Honeycutt Hills Community

Lot 25 – Stonefield 6 Model

AS-BUILT CONDITIONS

M+K Project #: 126-23047 (40/07)

SHEET No.
A3.2

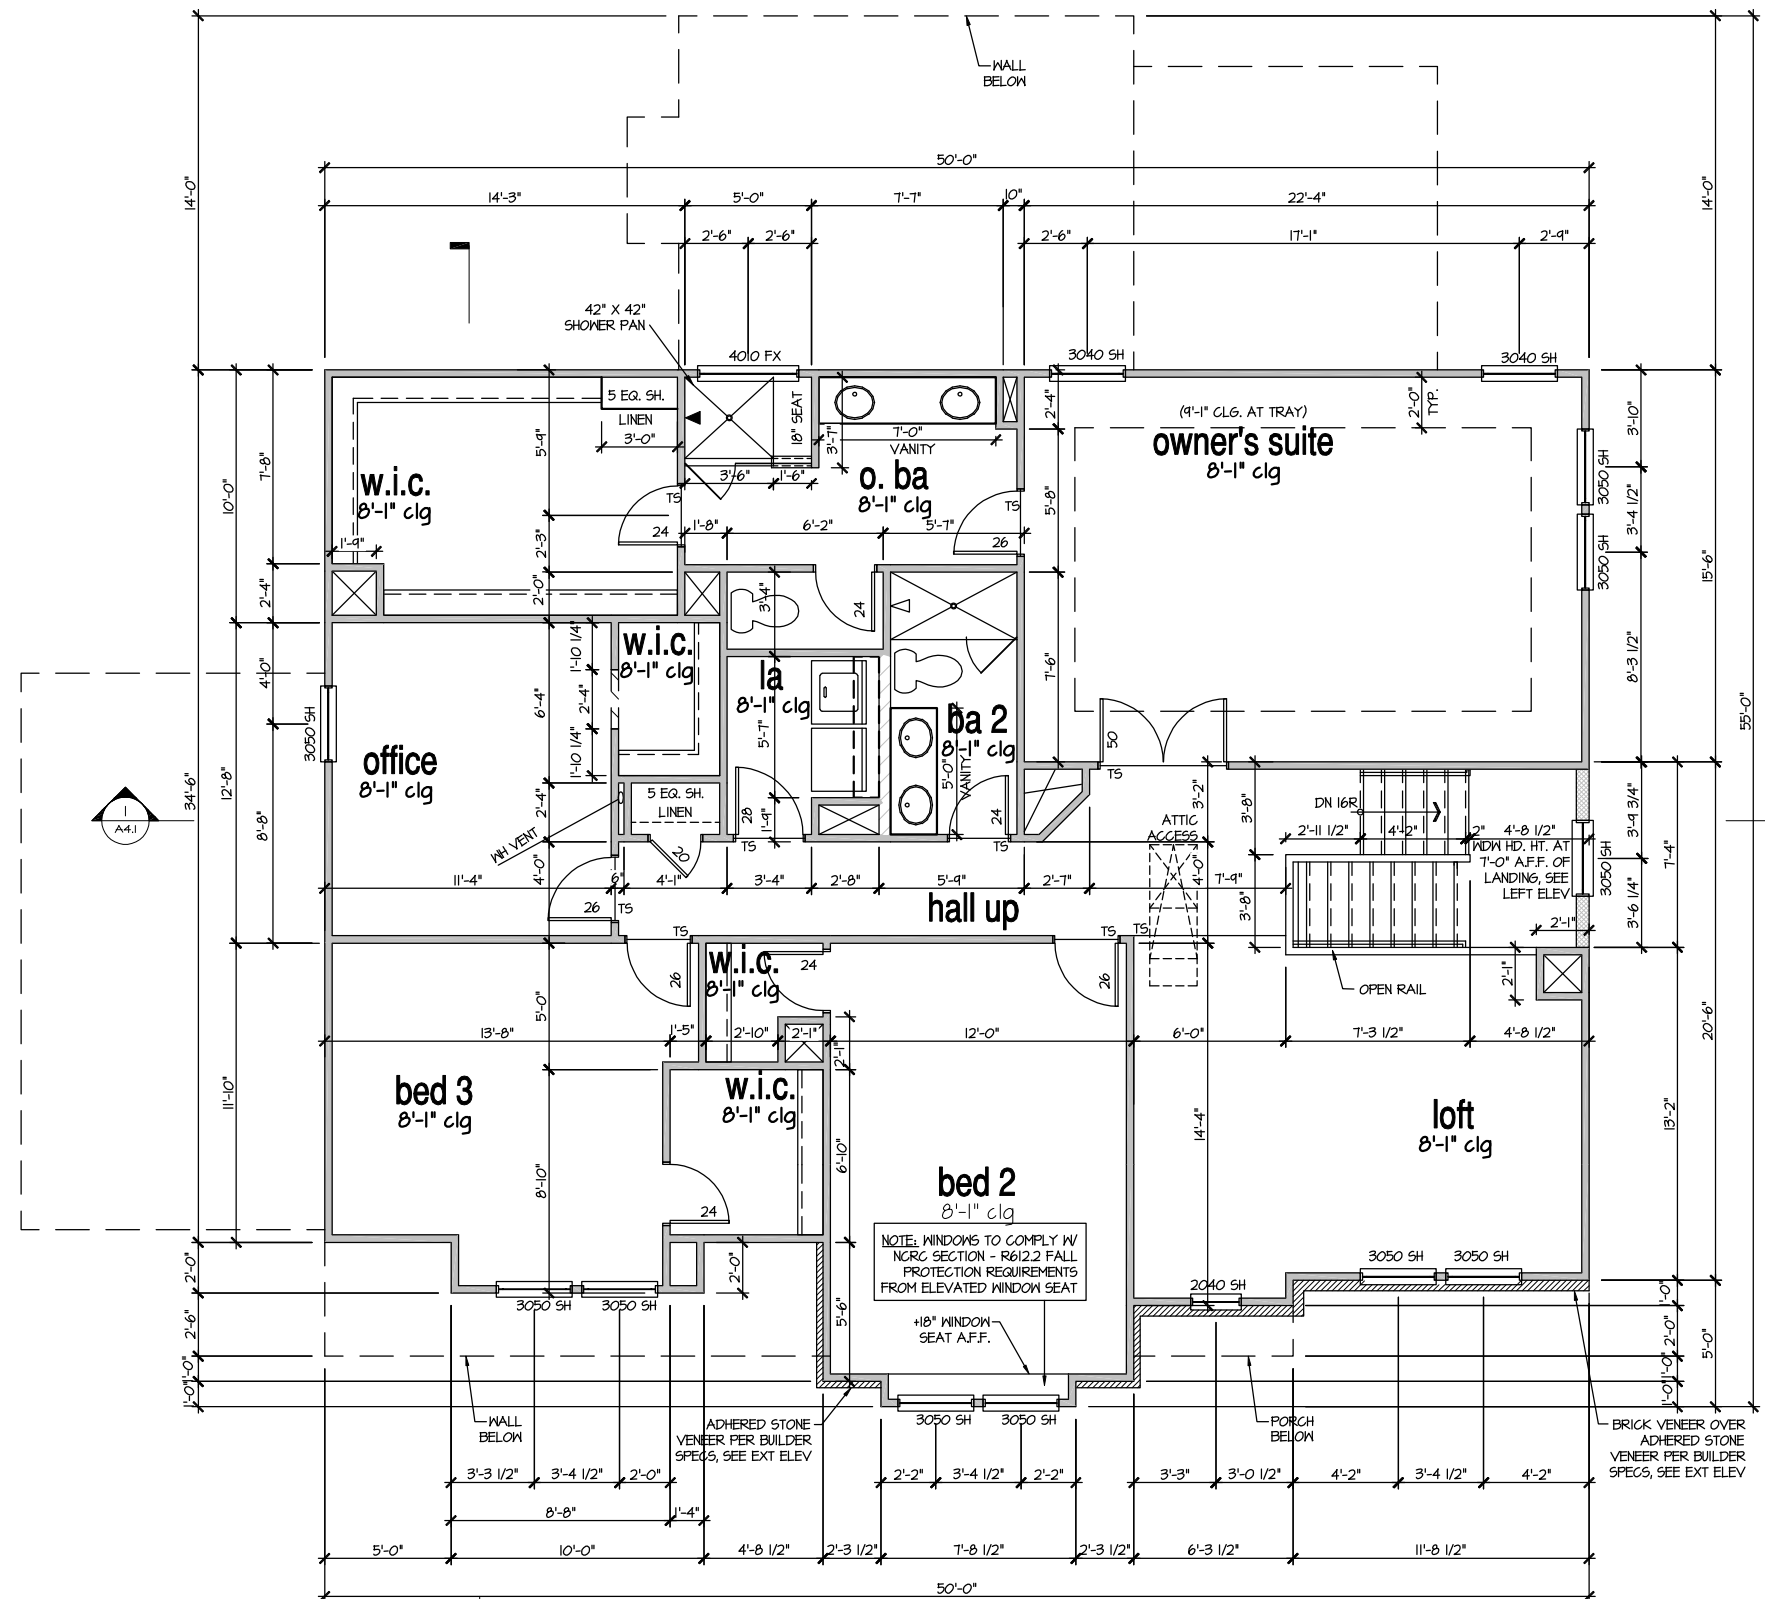
- It was reported to us, by you, that the stair landing was not framed per the structural plans. The structural plans call for a balloon-framed wall at the stairs. Instead, the wall was built with a (3)2x8 beam partly within the wall and flush with the landing. It is our understanding that this (3)2x8 beam was then toenailed with (8) nails into the 2x8 ledger beams on either side of the landing, which rest on short stud bearing walls.

We have analyzed the as-built condition, and it is our professional opinion that this method of framing the stair landing is NOT structurally adequate and a repair is required for this condition. See attached details 'A' and 'B'. Per repair detail A, (1) A34 clip must be added from the (3)2x8 flush beam to the 2x8 ledgers on both ends and fastened per manufacturer specifications. In addition, per repair detail B, the side 2x8 ledgers must be fastened to the full-height studs on either side of the landing per the nailing specified in the detail.
